Ref: MALS3002

APPLICATION TO VARY CONDITION 2 OF PLANNING PERMISSION REFERENCE LU/331/17/PL AT LAND AT LINESIDE INDUSTRIAL ESTATE NORTHWEST OF UNIT 26, ELDON WAY, LITTLEHAMPTON

PLANNING JUSTIFICATION

Drawing No.	Rev.
19005 - TP - 004	-

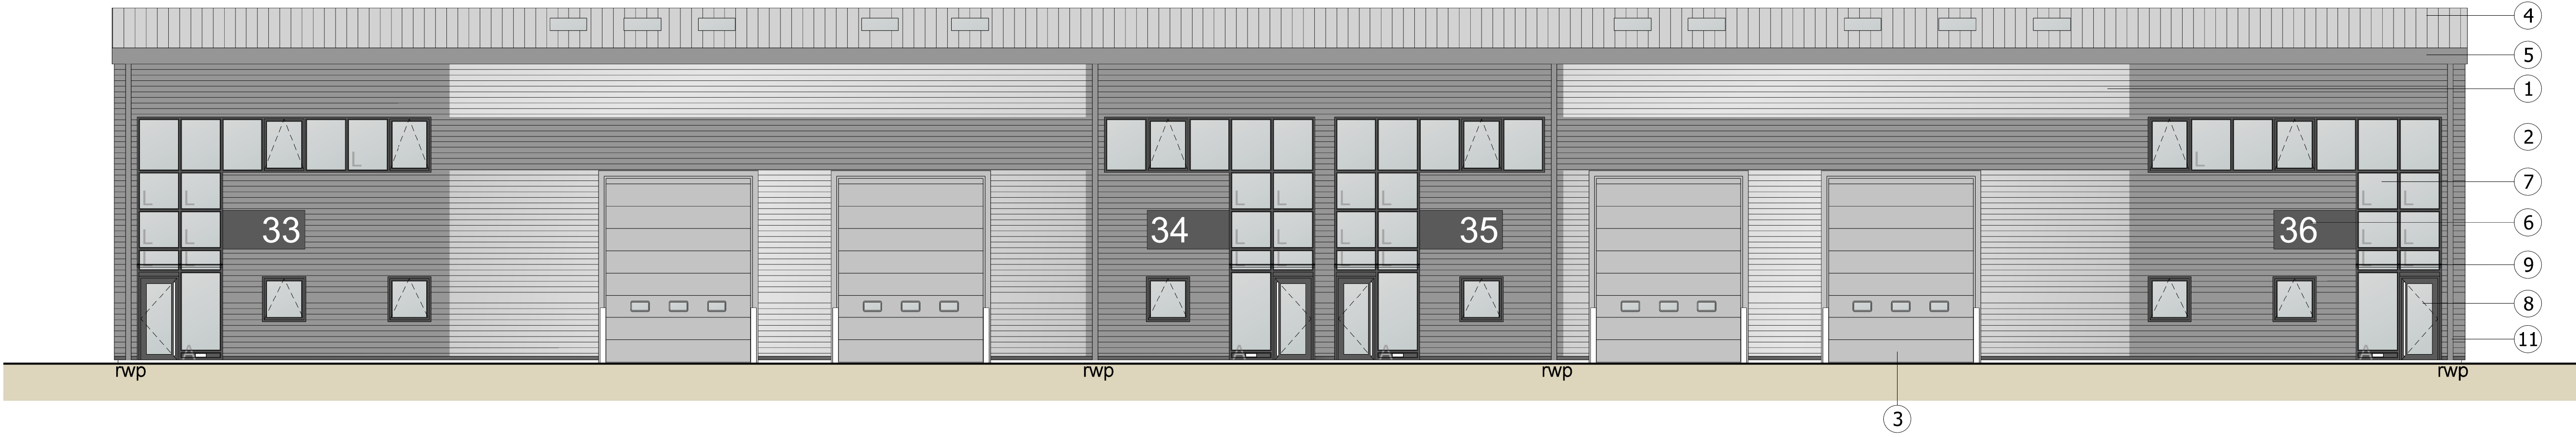
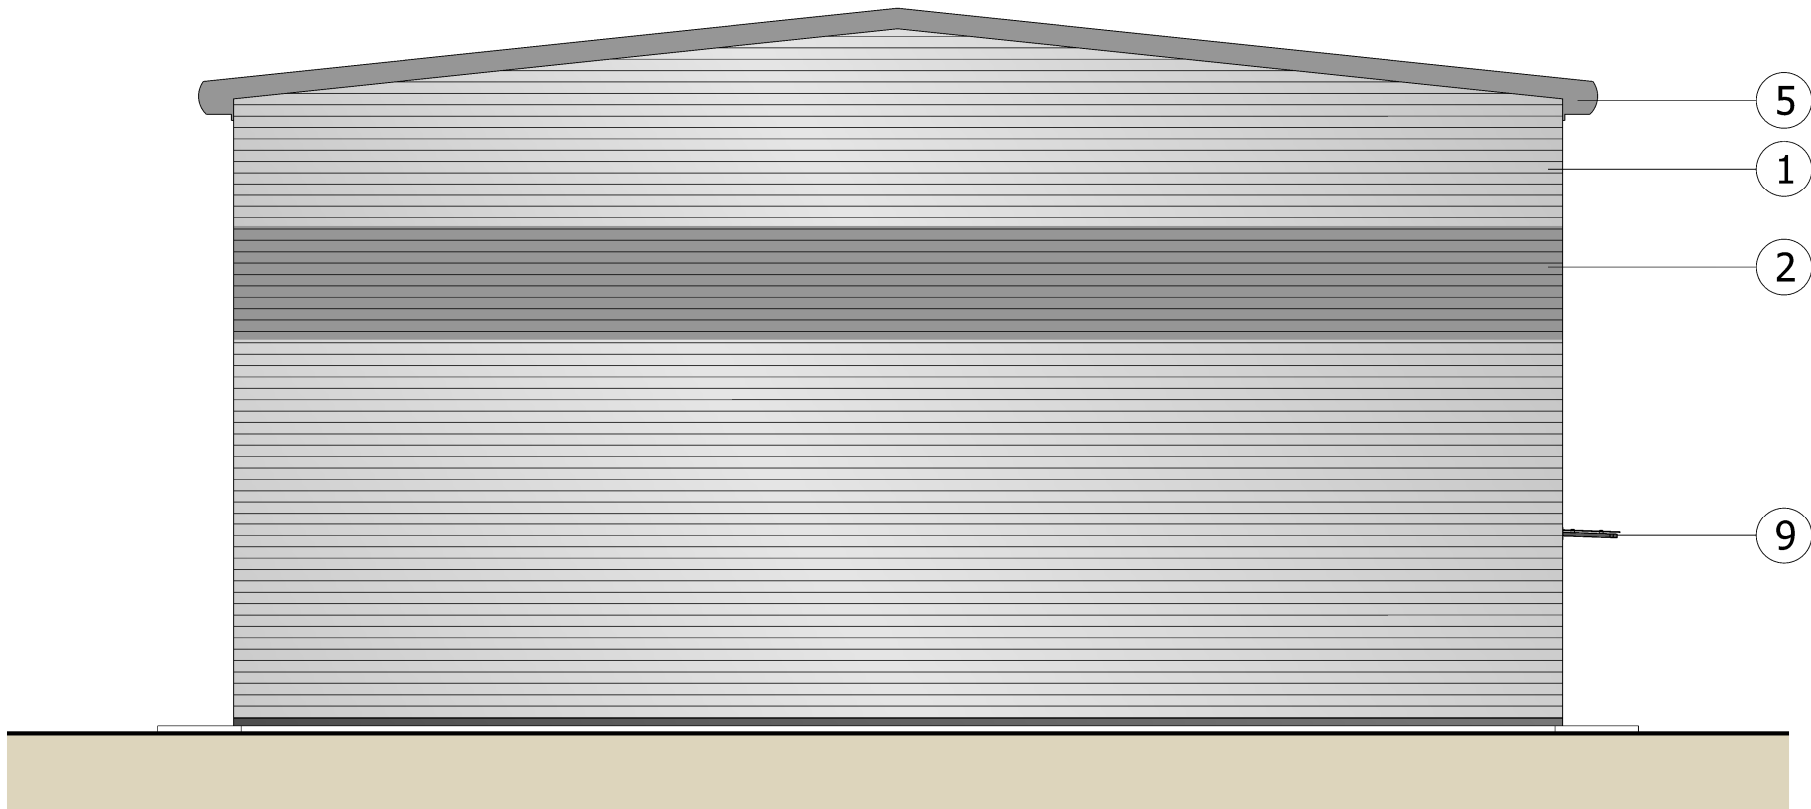
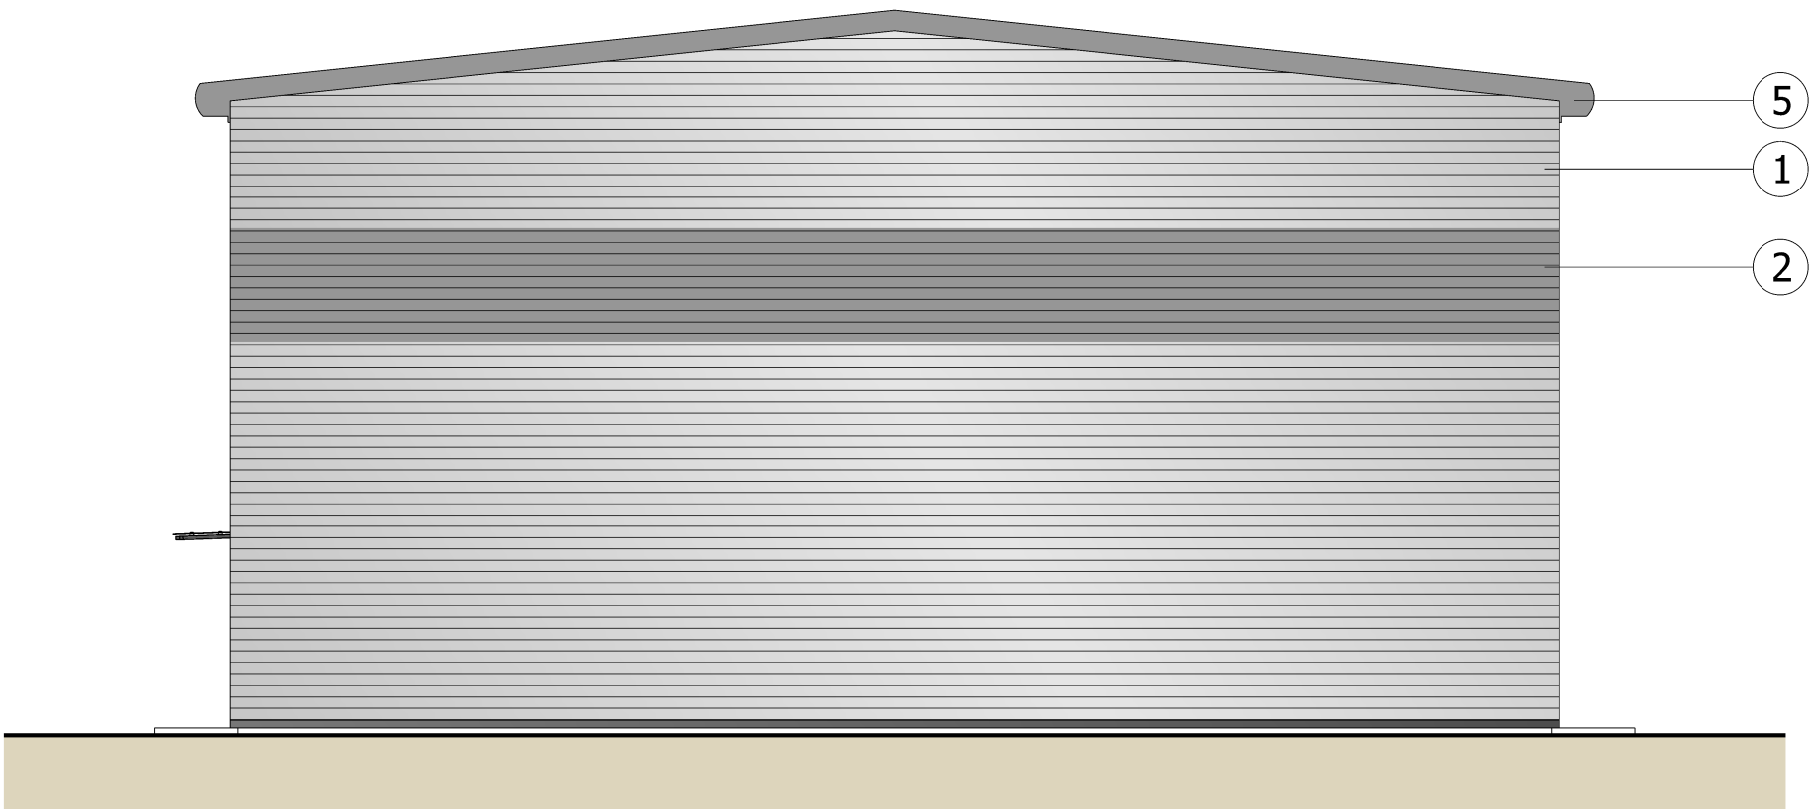
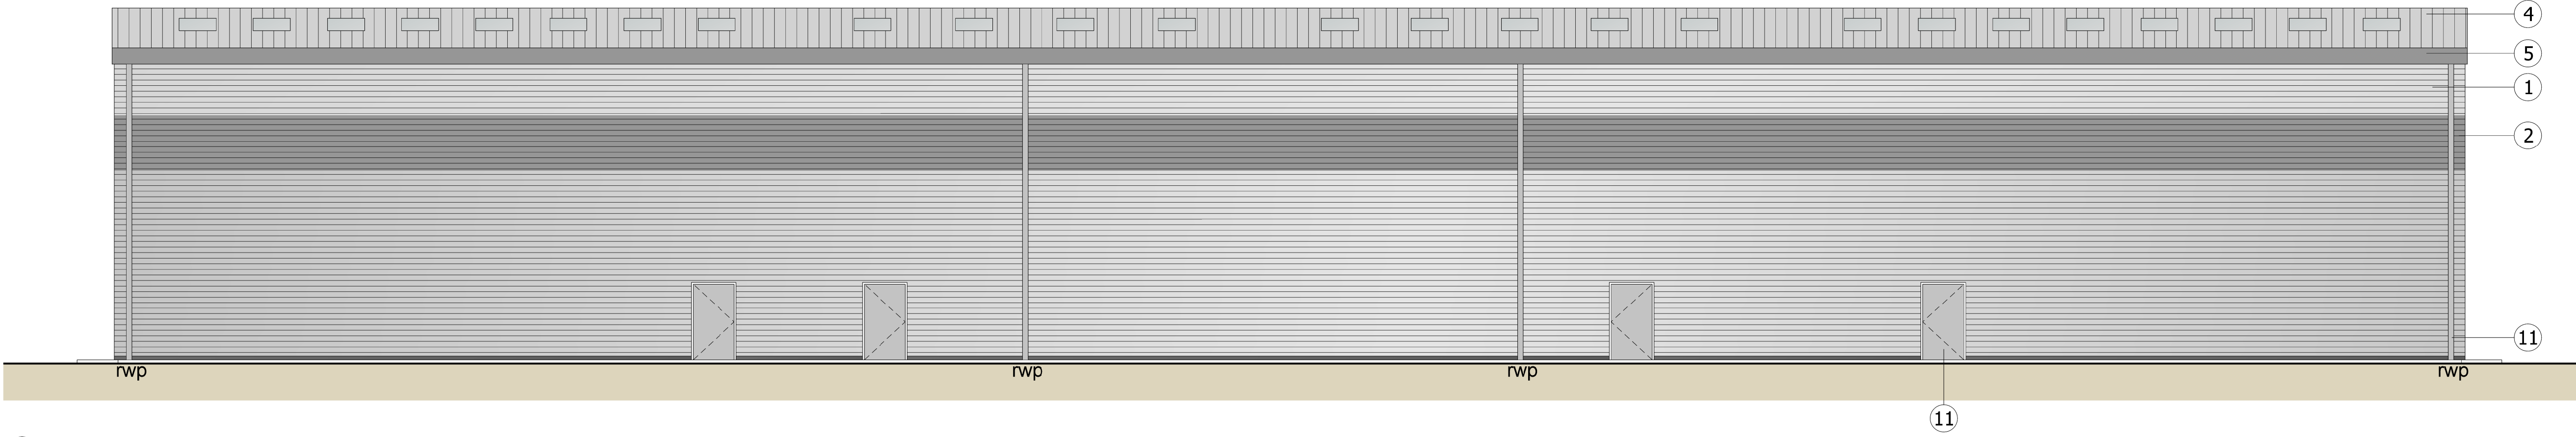
The second amendment has been to increase the size of the loading bay door on each unit so they measure 4 metres by 5 metres. Doing so means the proposed building will be in congress with the existing adjacent employment units which have similar sized loading bay doors. This revised size of loading bay door is also more in keeping with industry standards and would therefore be expected by future occupiers.

The fourth amendment has been to change the canopy above the main pedestrian entrance to each unit from a projecting metal canopy to a projecting glazed canopy. The proposed glazed canopies would appear lighter in the street scene compare to the metal canopies which would improve the appearance of the front elevation and the wider street scene.

The fifth and final amendment has been a reduction in the size of the eaves at the gable ends of the building. This approach is necessary from a maintenance perspective as it will improve accessibility to the

roof at the gable ends when workers need to use an aerial work platform to perform any necessary maintenance work.

Drawing No: **19005 - TP - 003** Rev: -

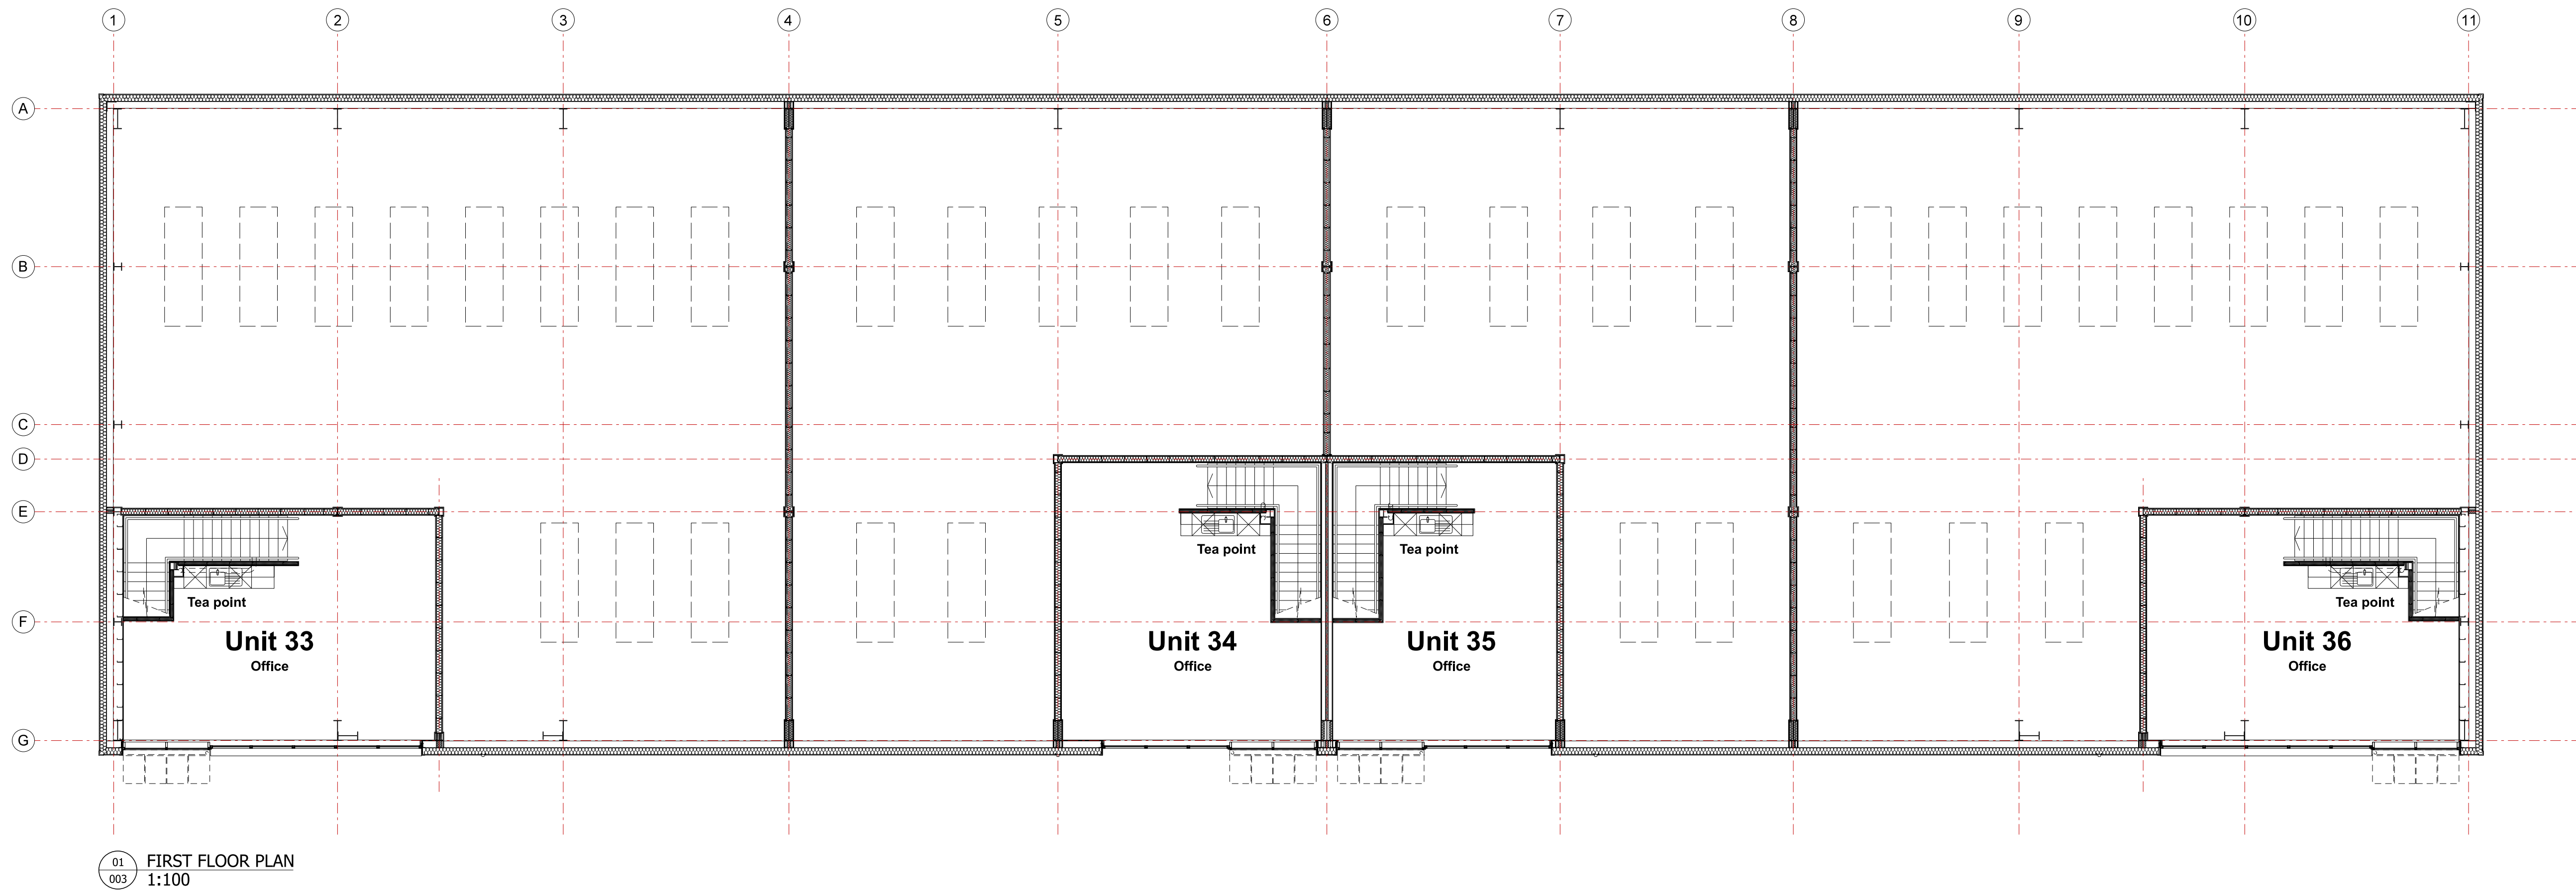
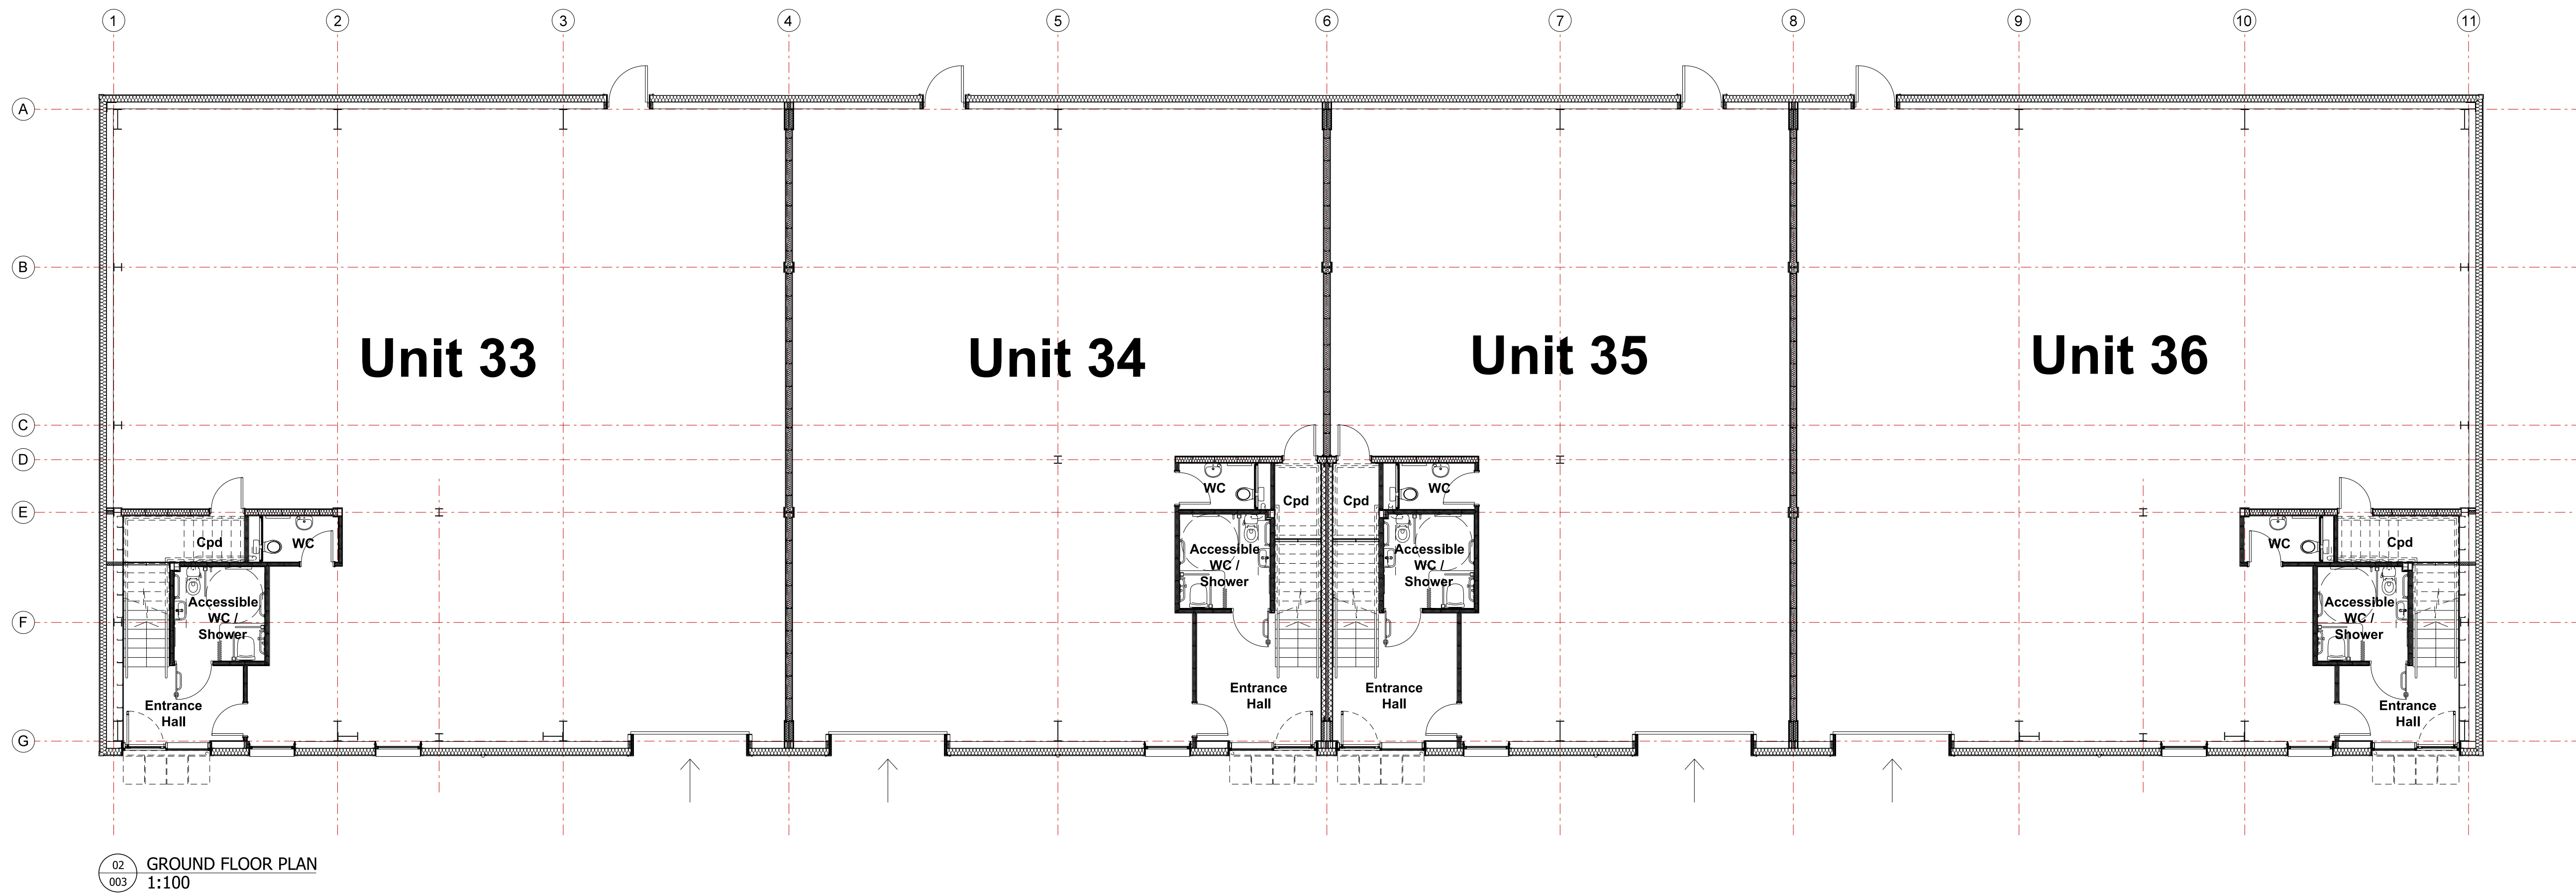
The first amendment has been to undertake some internal adjustments to the core around the staircase and ground floor WCs, including the accessible WCs, and also the first floor designs in order to ensure compliance with Building Regulations under Part M, BS8300 and The Equalities Act 2010. The adjustments have also provided more adequate headroom provision in the WCs located under the staircases and improved space for the WCs required services.
